ENVIRONMENTAL ASSESSMENT OF THE PROPOSED CRRRC

Response to Wallach - Critical Review of Geoscientific Component of TMES EA Final Version, February 2, 2015

Report Number: 12-1125-0045/13000

PROJECT			
CAPITAL REGION RESOURCE RECOVERY CENTRE			
TITLE			
LOCAL BEDROCK SURFACE ELEVATION MAP			
	PROJECT No. 12-1125-0045		SCALE AS SHOWN
	DESIGN	NB 15 NOV. 2013	REV.0
	GIS	NB 15 NOV. 2013	
	CHECK	PLE AUG. 2014	
	REVIEW	PAS AUG. 2014	
			FIGURE 3-5

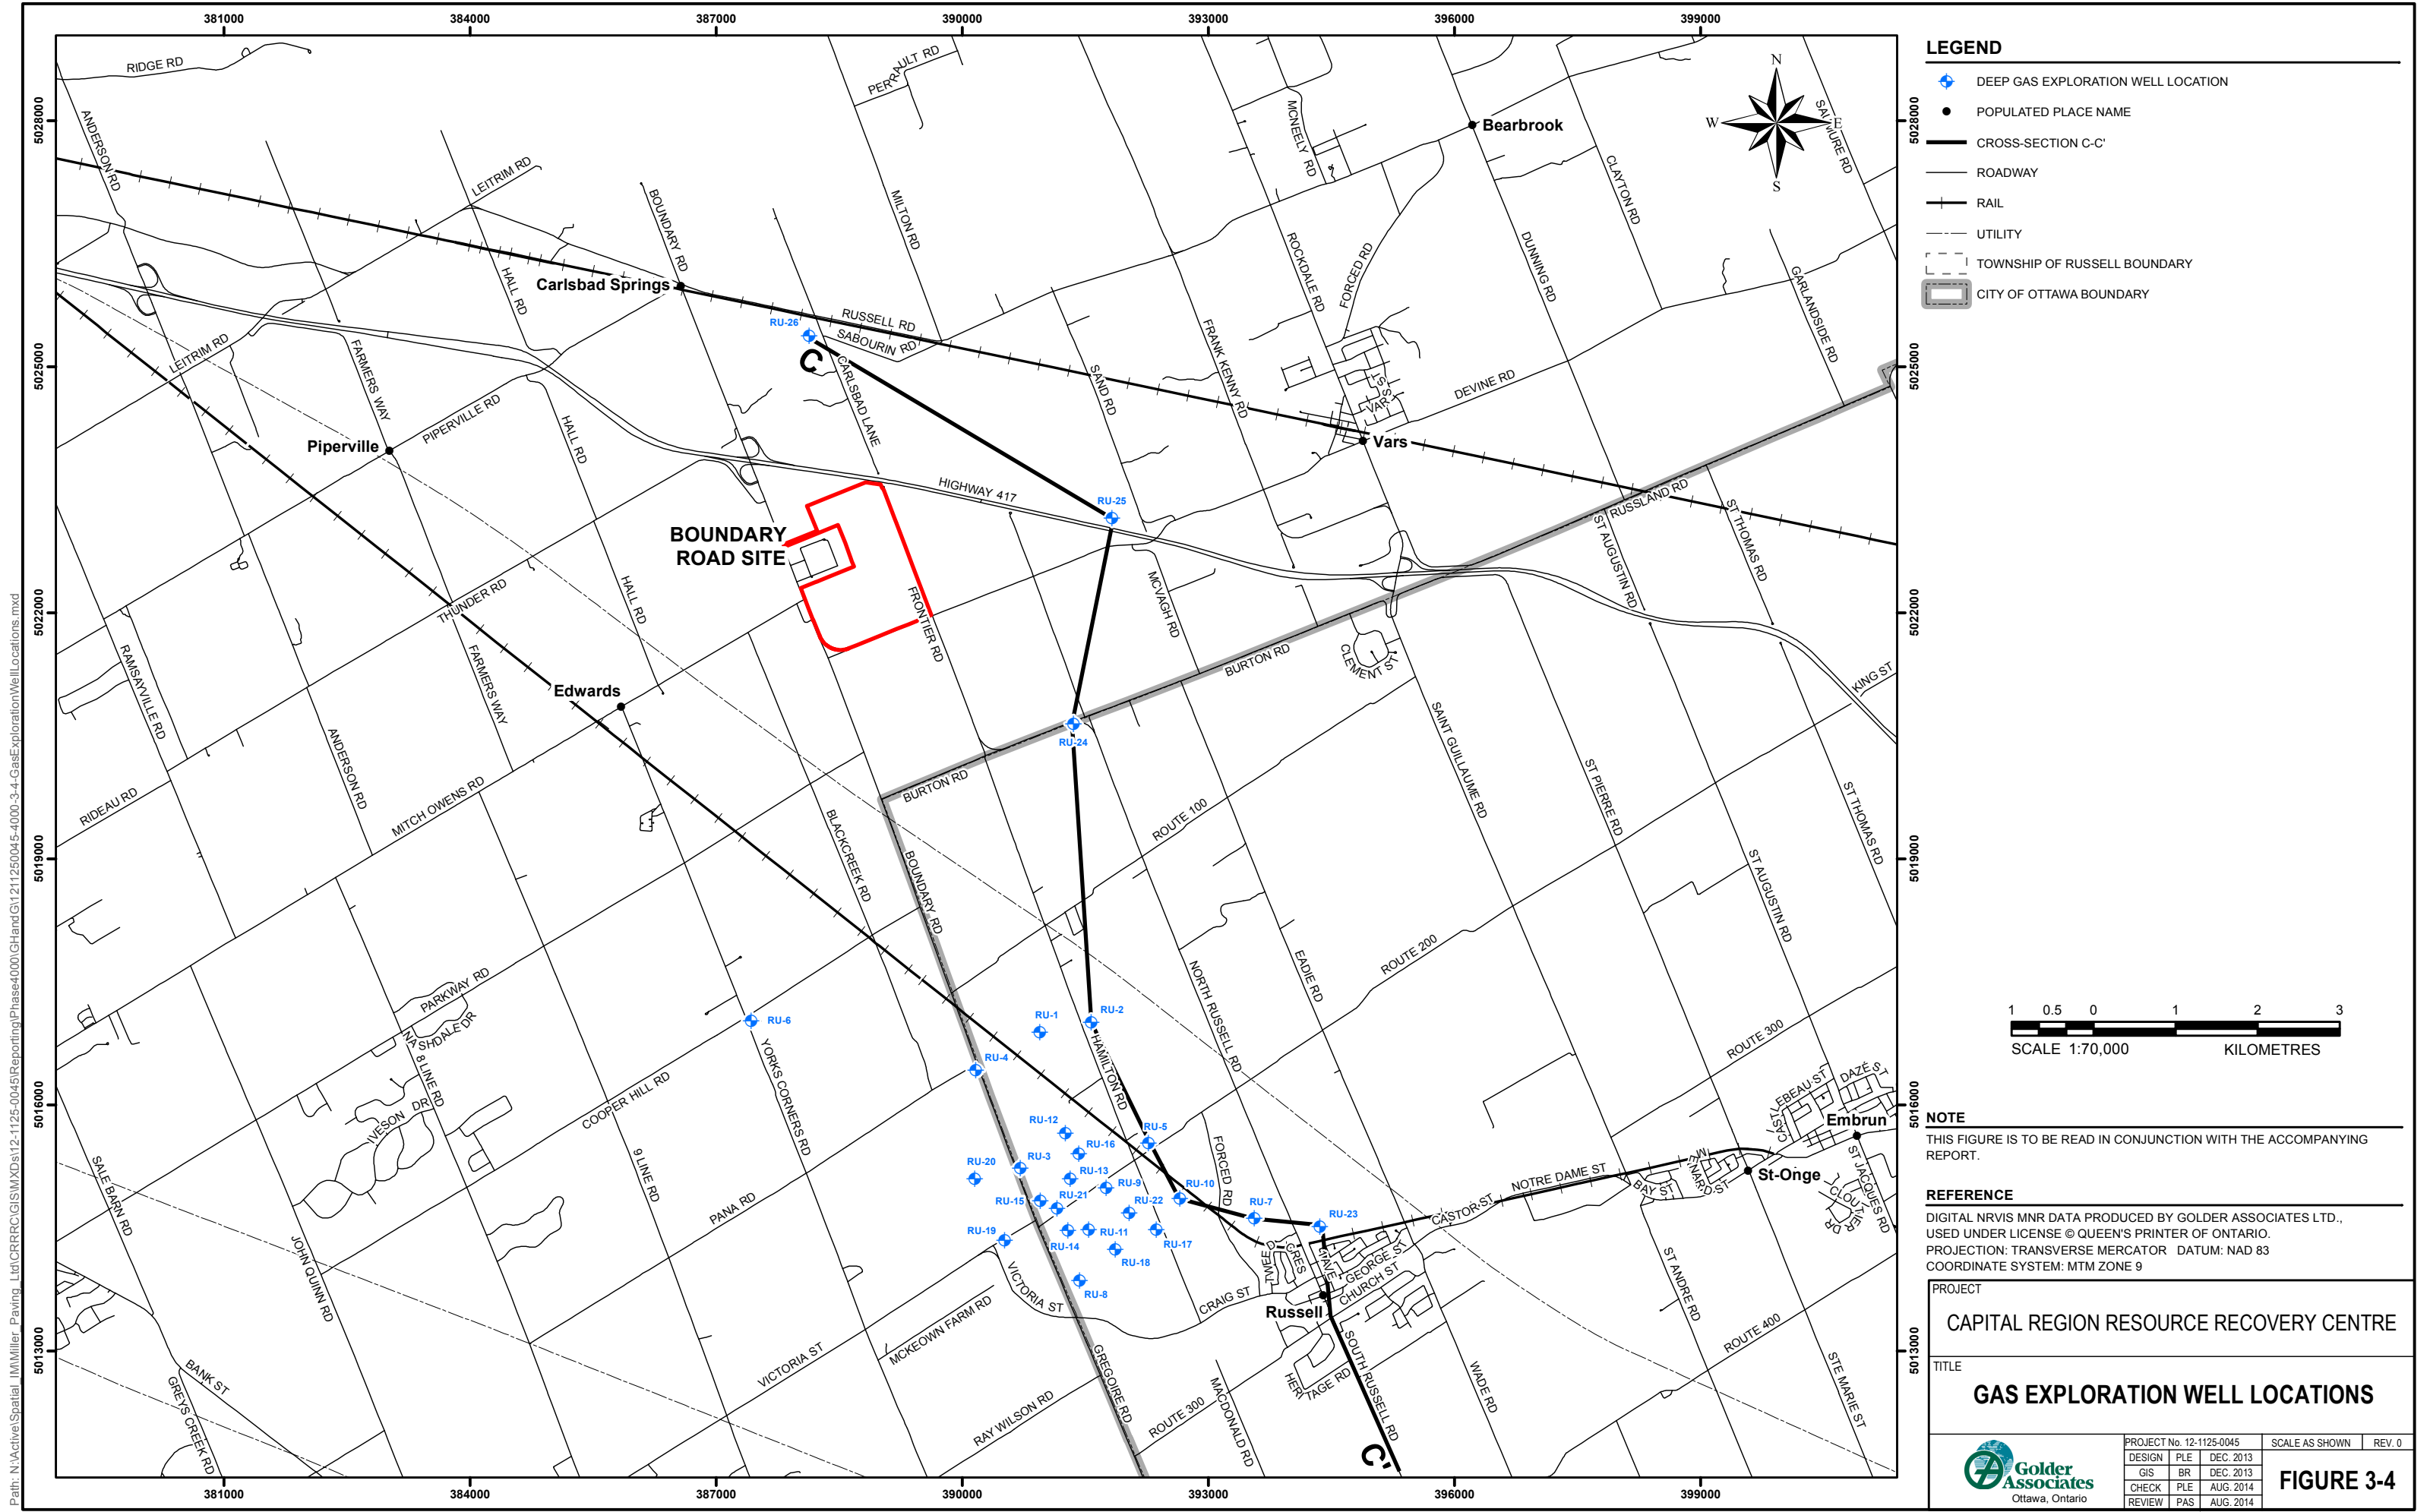
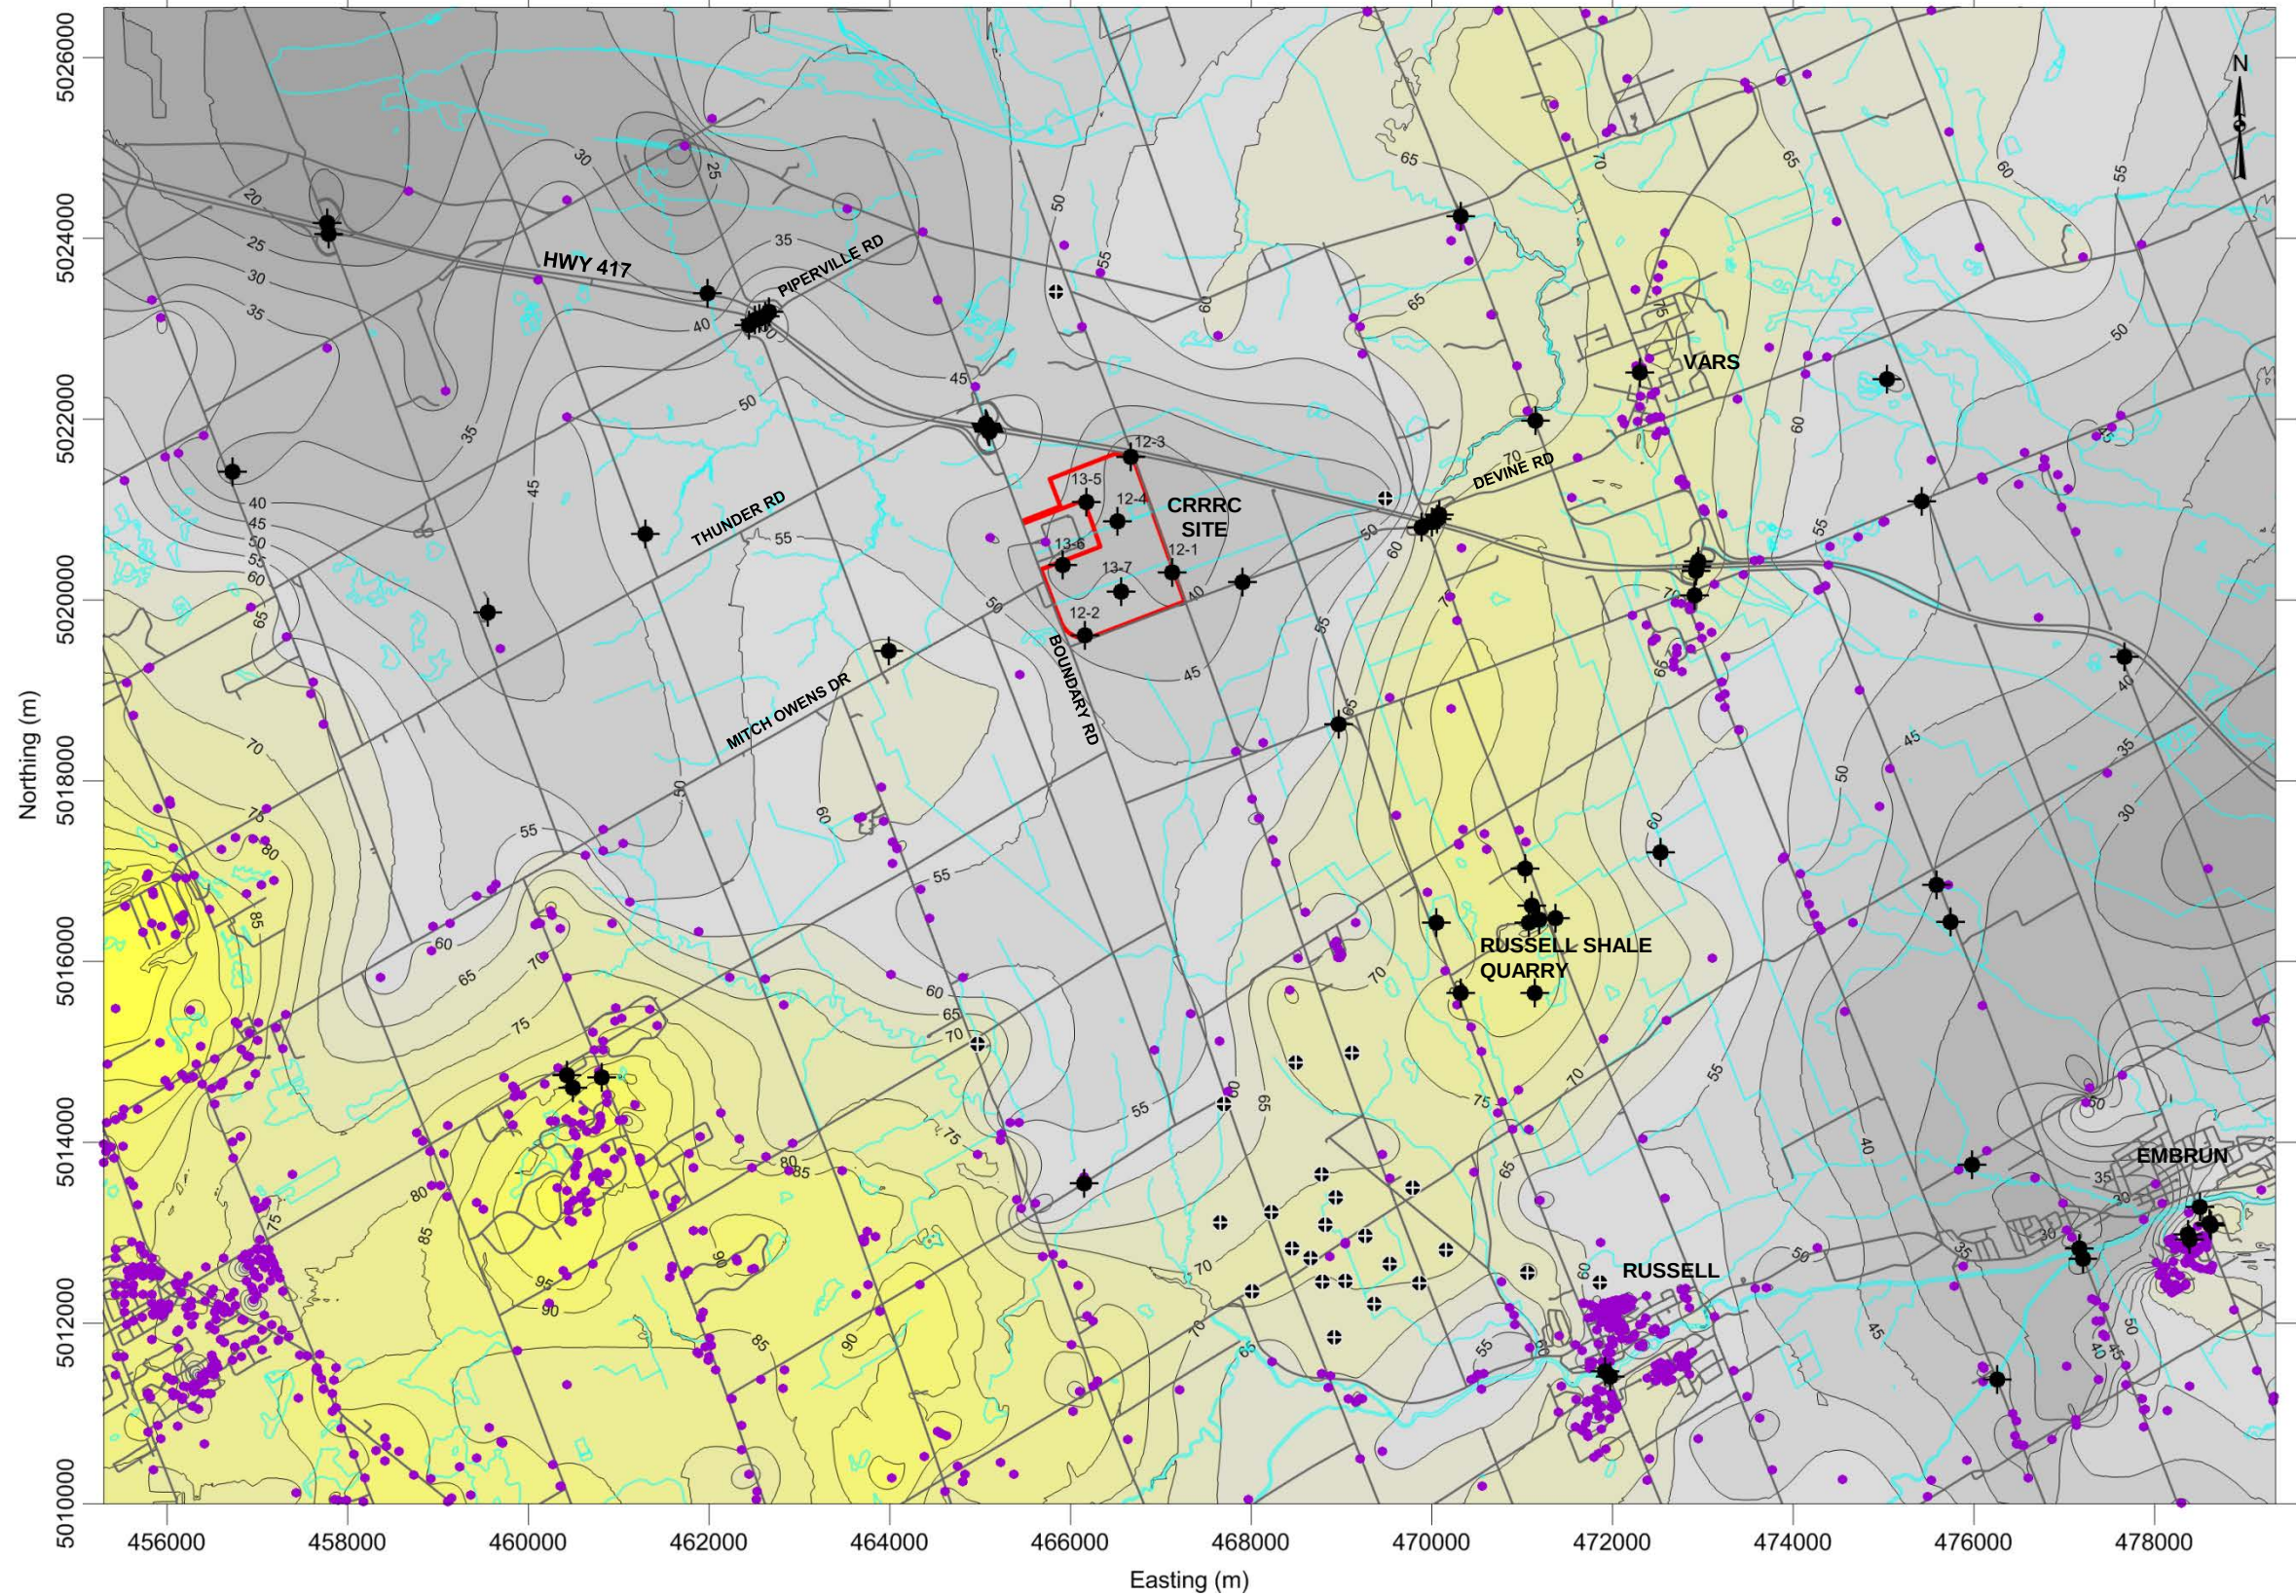
Wallach (2014) interpretation of the structural geology in the area studied relies heavily on data obtained through the MOECC WWIS database. Our first concern with using MOECC WWIS data is the accuracy of the well locations provided in the database. In order to evaluate the well location accuracy, the MOECC WWIS database provides codes for wells based on the reliability of their location coordinates. The MOECC WWIS well location accuracy codes are provided in the table below. The appropriate level of screening of the MOECC data depends partly on the scale and type of project-specific analysis undertaken and the number of available data points. We consider it is prudent (and good practice) to remove all wells with a location accuracy of less than 100 m (i.e., remove all wells with a location accuracy code of 5 or greater).

Although the well location accuracy codes were not included in Wallach (2014), we determined the codes by geo-referencing Wallach (2014) Figure 12 (and Table 3) and matching well records in the MOECC WWIS database to those on Figure 12 and in Table 3. In total, 36 of the 102 wells used in the Wallach (2014) analysis (35%) have an accuracy code of 9 (i.e., having “unknown coordinates”), one well has an accuracy code of 5, and one well has no code. All remaining wells have an accuracy code of 4 or lower. Of the 102 wells, therefore, only 64 (63%) have, in our opinion, an acceptable accuracy code. The spatial distribution of the “code 9” wells used in Wallach (2014) is illustrated on the attached Figure 1.

The first example is related to three wells illustrated on Wallach (2014) Figure 12, located in the northwest (upper left) corner of Figure 12, immediately to the west of the Boundary Road Site. Two of these three wells have been assigned a top elevation of the Carlsbad Formation bedrock of 75 mASL (referred to as the “75” wells); one well has been assigned an elevation of 72 mASL (referred to as the “72” well), and are herein referred to as the “northwest corner wells”. Wallach (2014) has interpreted a fault roughly along Boundary Road immediately to the east of these “northwest corner wells” because other nearby wells have top surface elevations of the Carlsbad Formation at about 35 m lower than the “northwest corner wells”. In Section C Letter # 1 of Wallach (2015), there is specific mention of the discussion between Golder Associates’ staff and Dr. Wallach at the June 2013 Groundwater Workshop in regard to the WWIS accuracy codes (of which Dr. Wallach was previously unaware), these same three well records and the presence of the fault inferred by Dr. Wallach from this data. Dr. Wallach describes the method he then used to try to verify the location of water wells in the general location where these three well records plot on a map. However, locating a well in the

field that approximates one reported in the WWIS does not inform the subsurface conditions encountered at that location; that has to be obtained from the WWIS data base. The WWIS data base provides the subsurface information in two ways: 1) a summary of the materials encountered and their thickness and 2) access to a copy of the actual driller's log based on the well number. From the MOECC WWIS database, and using the well numbers assigned to these three "northwest corner wells", we have matched three well records to the location coordinates of the two 75 mASL wells, which include Well ID 5603177 for the northernmost "75" well, and Well IDs 5603178 and 1523770 for the southernmost "75" well. For the "72" well, Well ID 1524478 has been matched to this location. The records for these identified wells show that these wells are all located in Marionville, Ontario, approximately 16 km southeast of the locations illustrated on Wallach (2014) Figure 12 (well records and location maps are provided in Appendix A). The geological information provided on these records is representative of the conditions in Marionville, where bedrock is present at shallow depth at ground surface. It is not representative of the subsurface conditions in the area of the Boundary Road Site, which consist of an approximately 30 metre thick deposit of silty clay. The main implication of this error in Wallach (2014) is that without the "northwest corner wells", no information exists to support the interpreted fault in the northwest corner shown on Wallach (2014) Figure 12 that is immediately west of the proposed CRRRC Boundary Road Site.
